KIRKLEES METROPOLITAN COUNCIL INVESTMENT & REGENERATION SERVICE

DELEGATED DECISION TO DETERMINE APPLICATIONS FOR LISTED BUILDING CONSENT

Reference No:	2024/65/92106/E
Site Address:	Wesley House, Huddersfield Road, Birstall, Batley, WF17 9AZ
Description:	Listed Building Consent for alterations to convert former offices to 21 apartments (within a Conservation Area)
Recommending Officer:	Nina Sayers

Officer Report

Proposed Side Elevation (West Facing)
1:100 @ A1

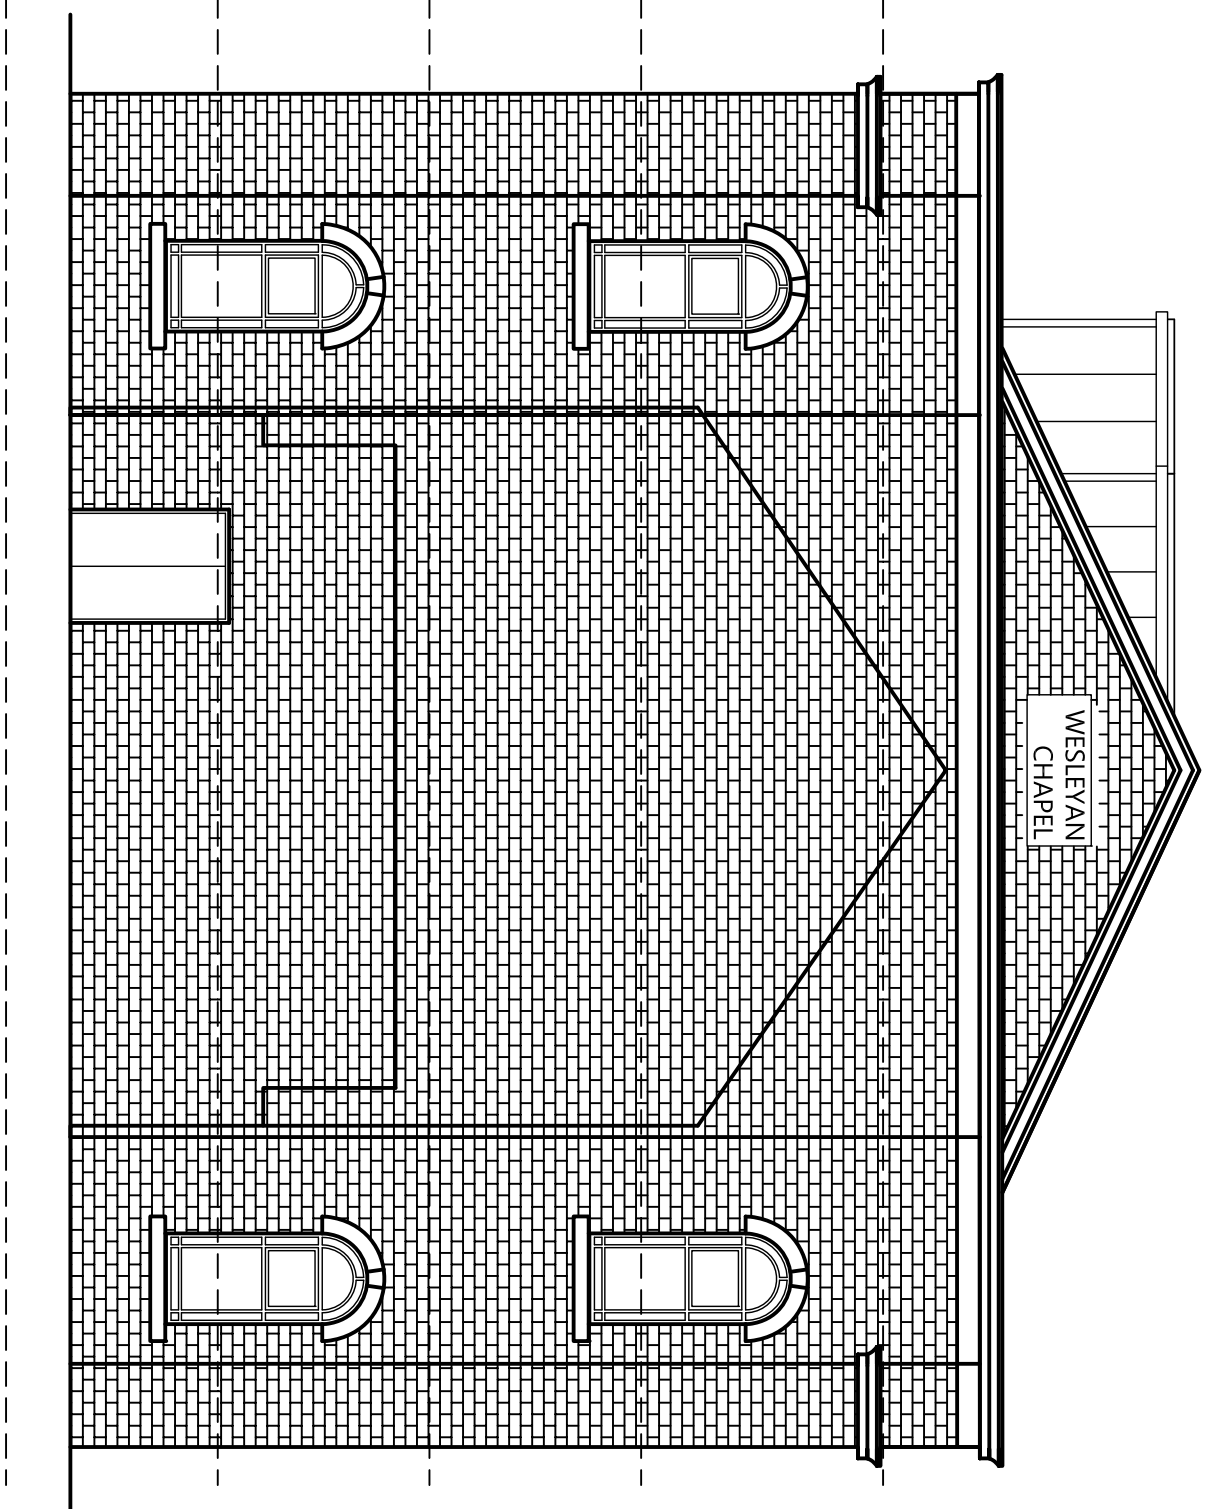
Initially the scheme proposed a lift shaft, which protruded out the roof face of the building, serving lift access to the fourth floor. Officers raised concerns regarding the impact of this on visual amenity and the listed building’s heritage value. As a result, amended plans were received which removed the protruding element whilst retaining the internal lift.

Plan :
Proposed Floor Plans

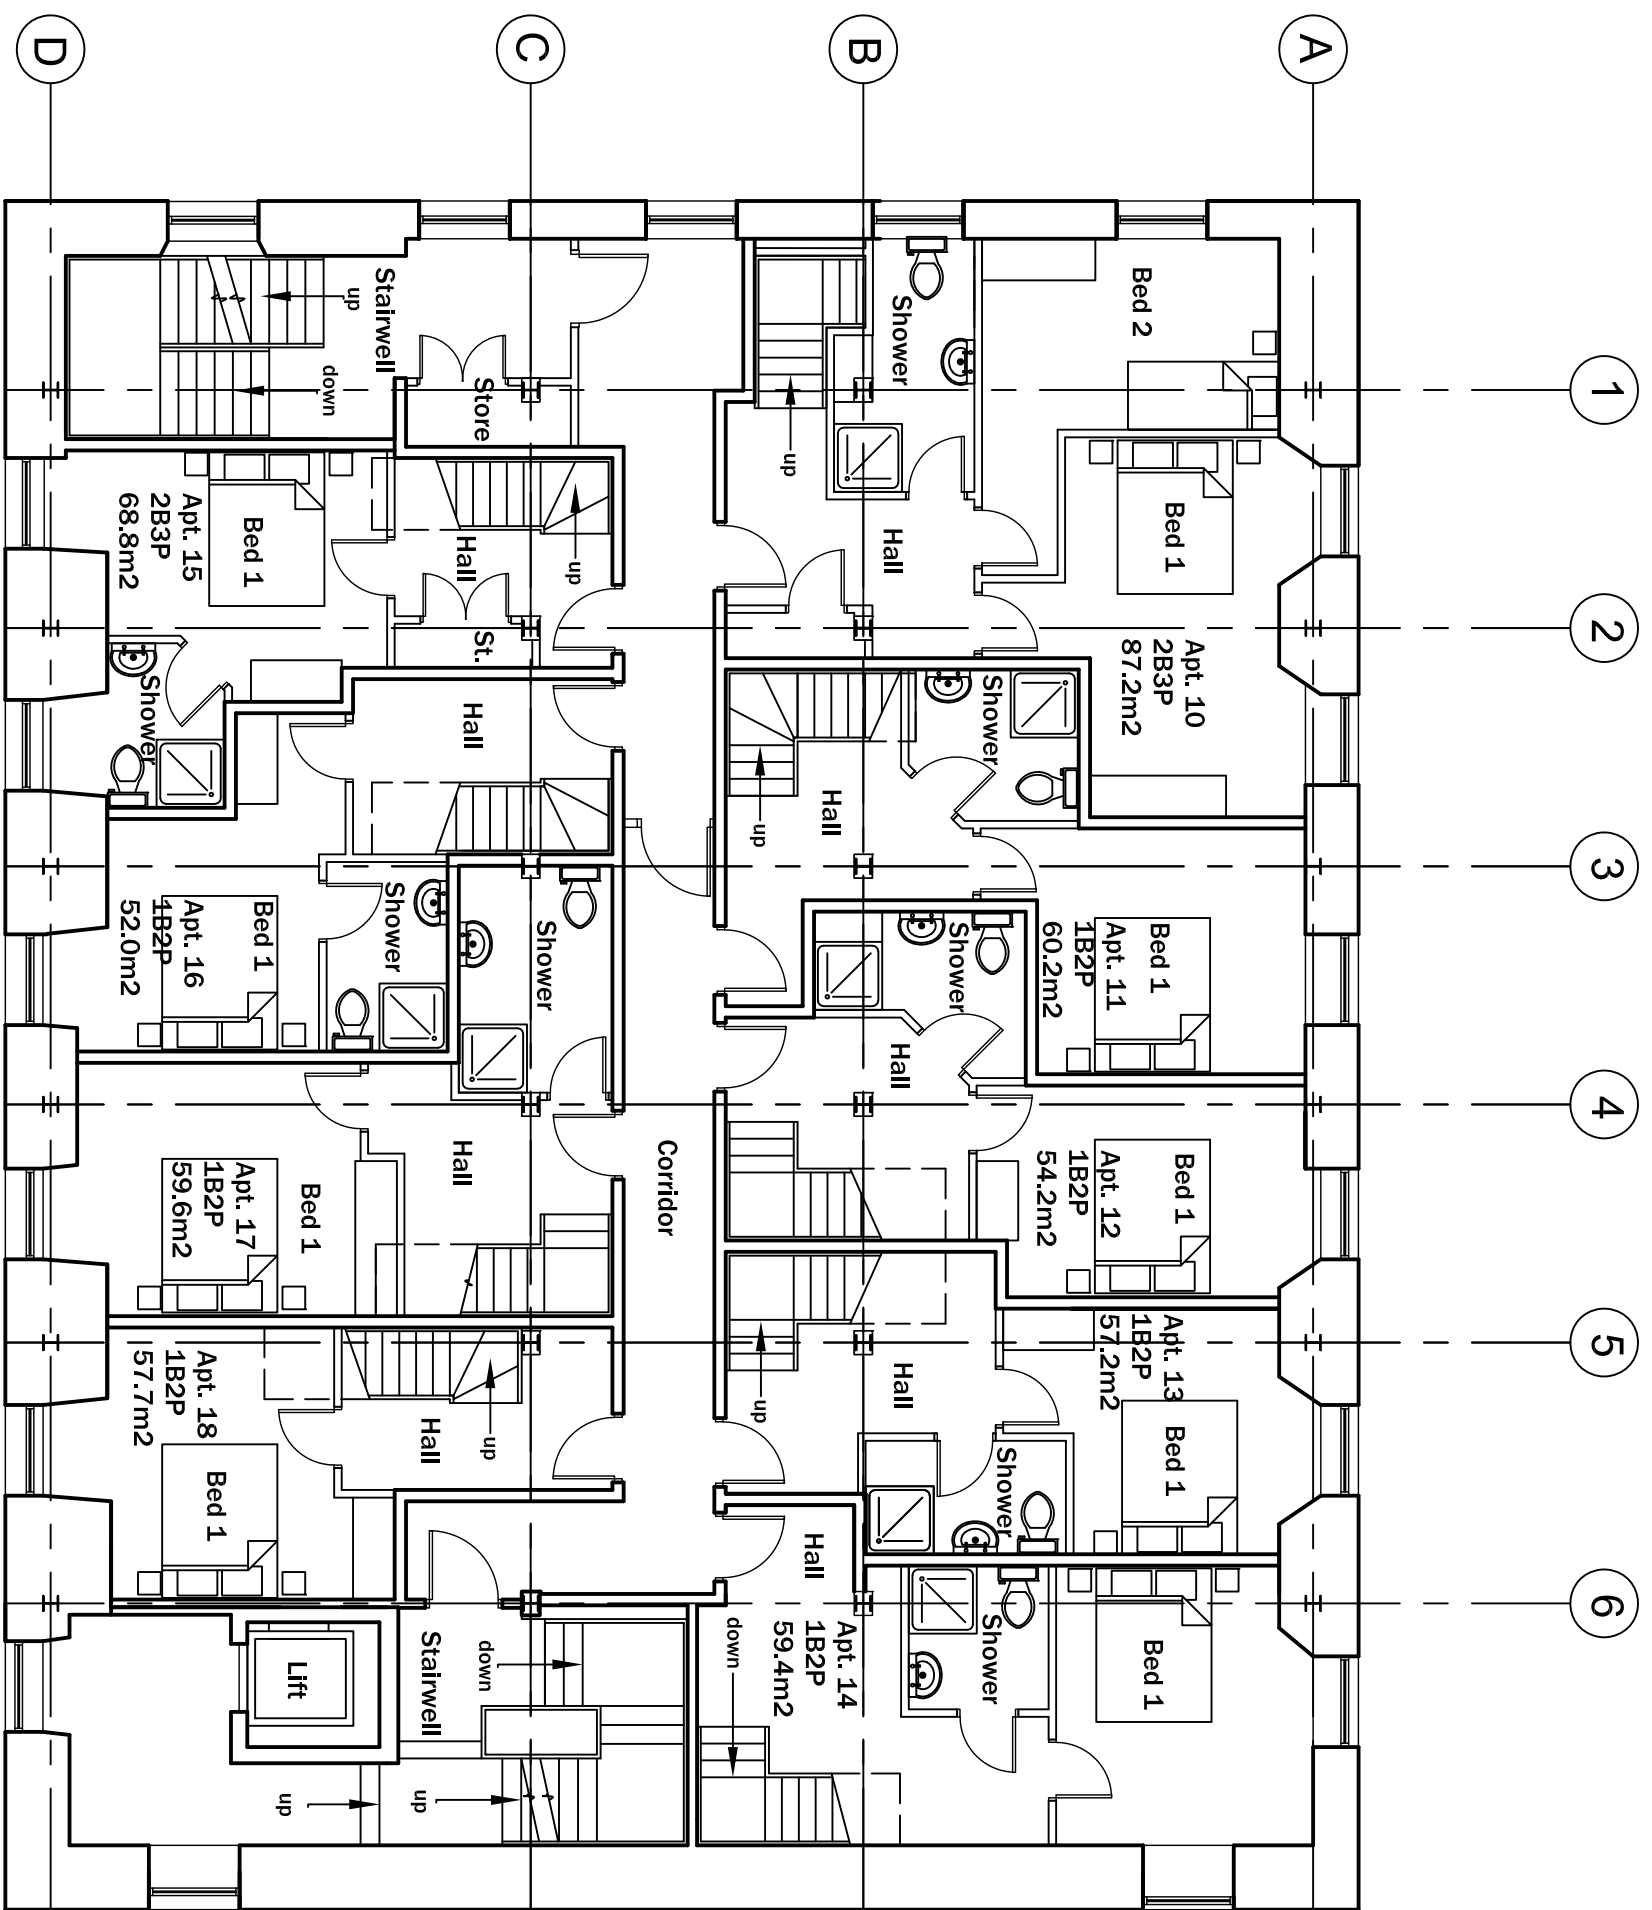
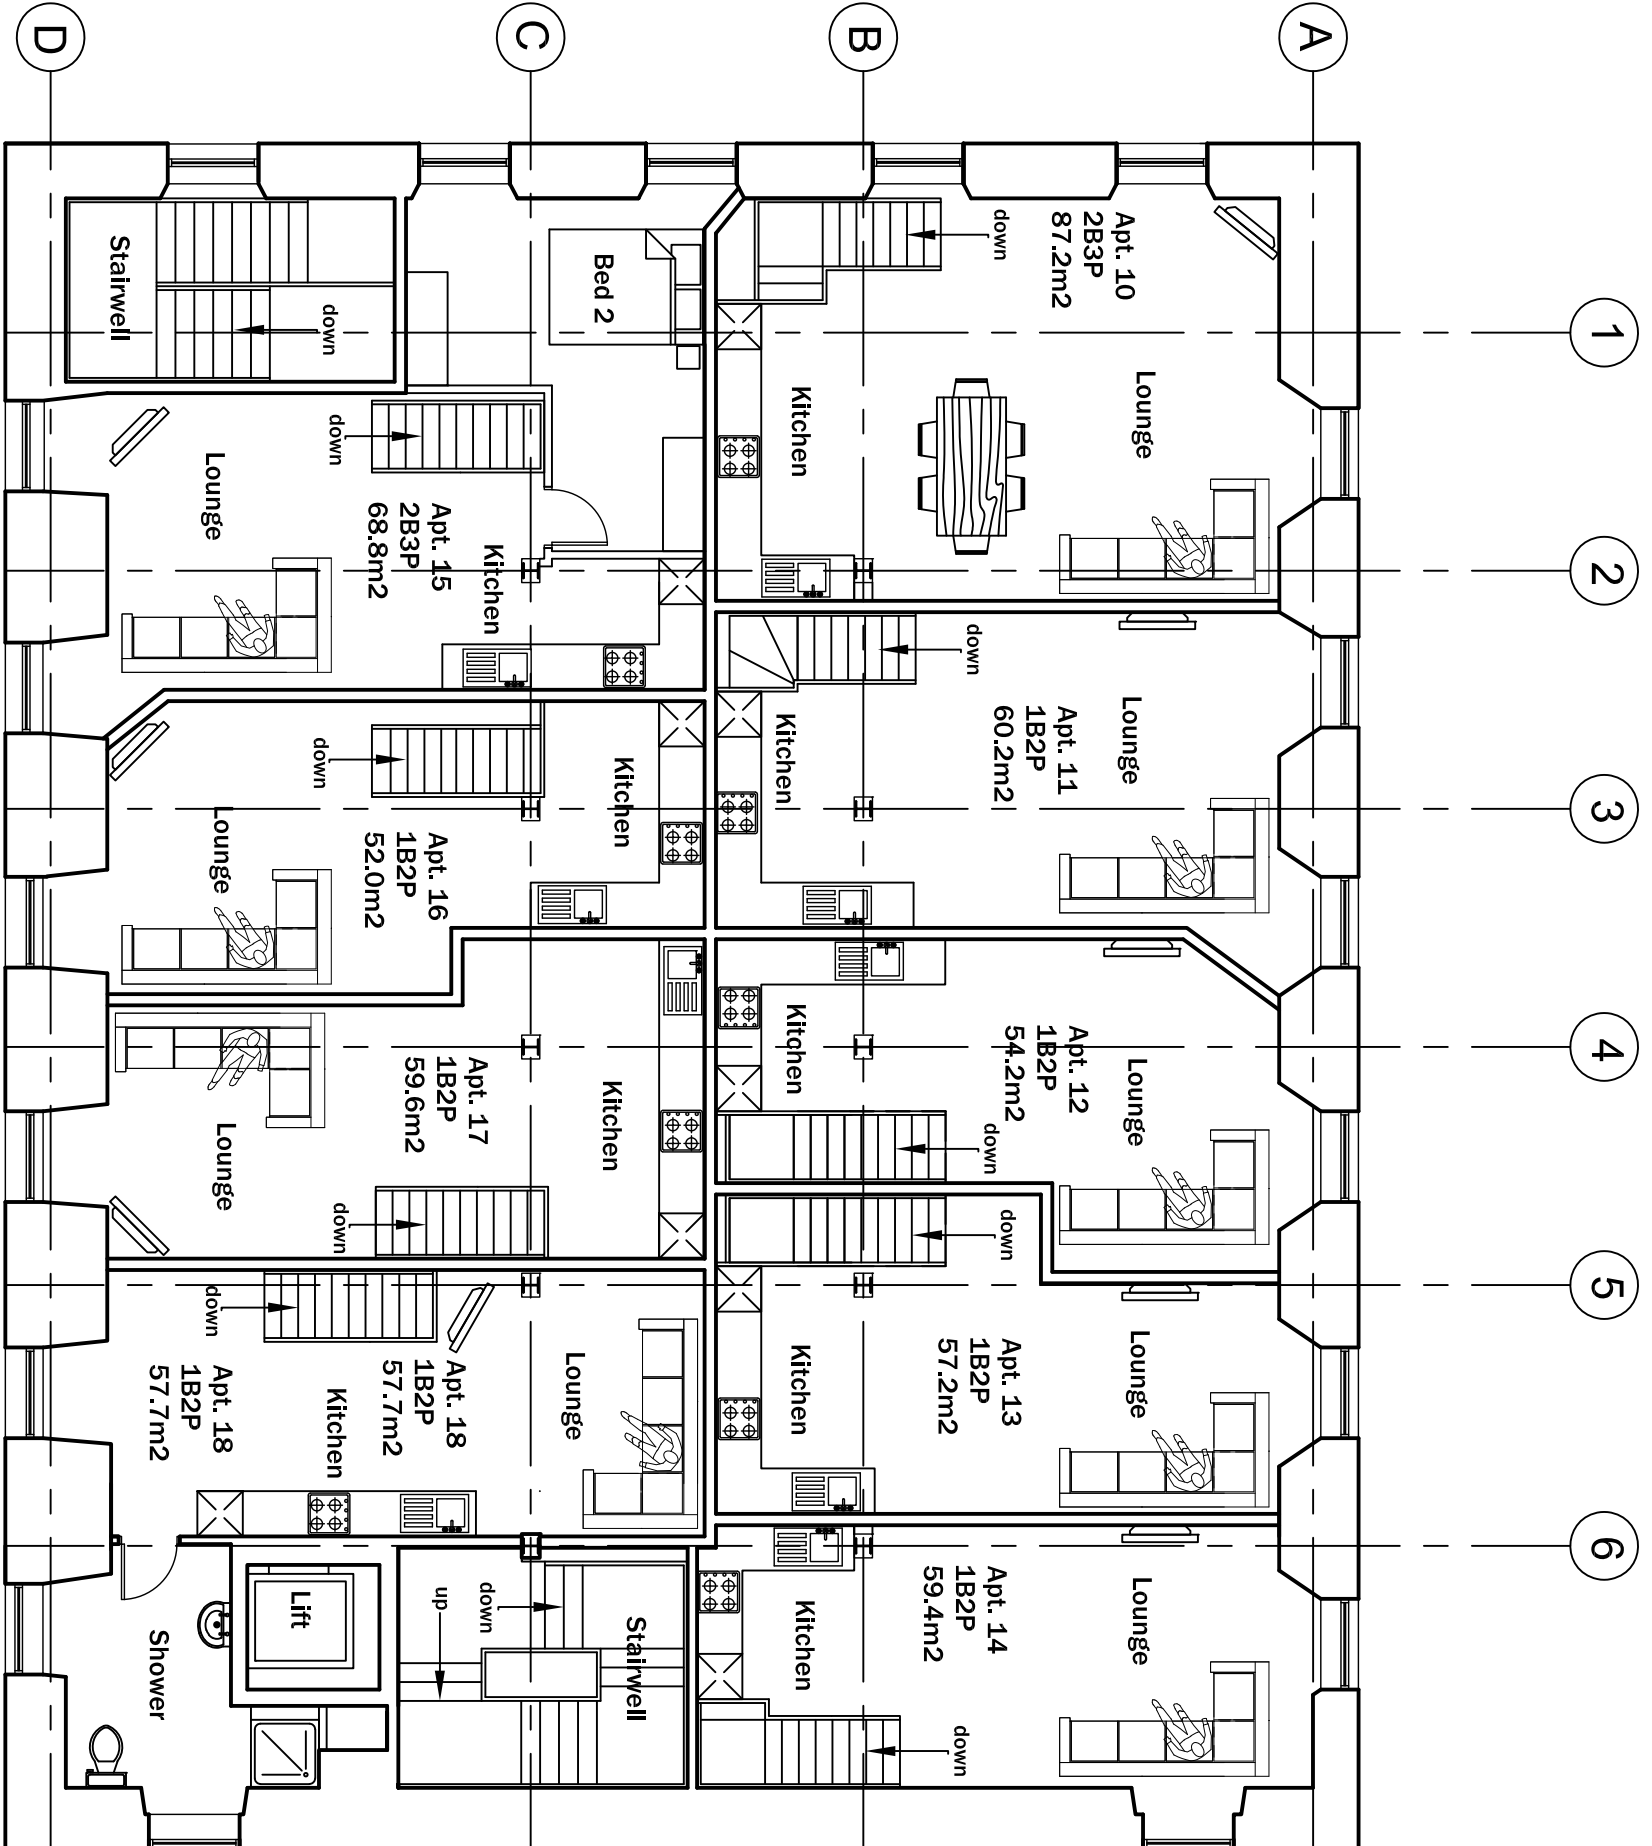
Officers had concerns regarding the ground and second floor living accommodation which is only served by small openings. The applicant

discussed the idea of adding additional openings however, in the interest of preserving the listing building and not causing harm to visual amenity, officers outlined they would not support additional openings. Instead, a revised internal layout was provided which proposed the kitchen area to the lower levels and all other living accommodation to the upper levels which have larger openings.
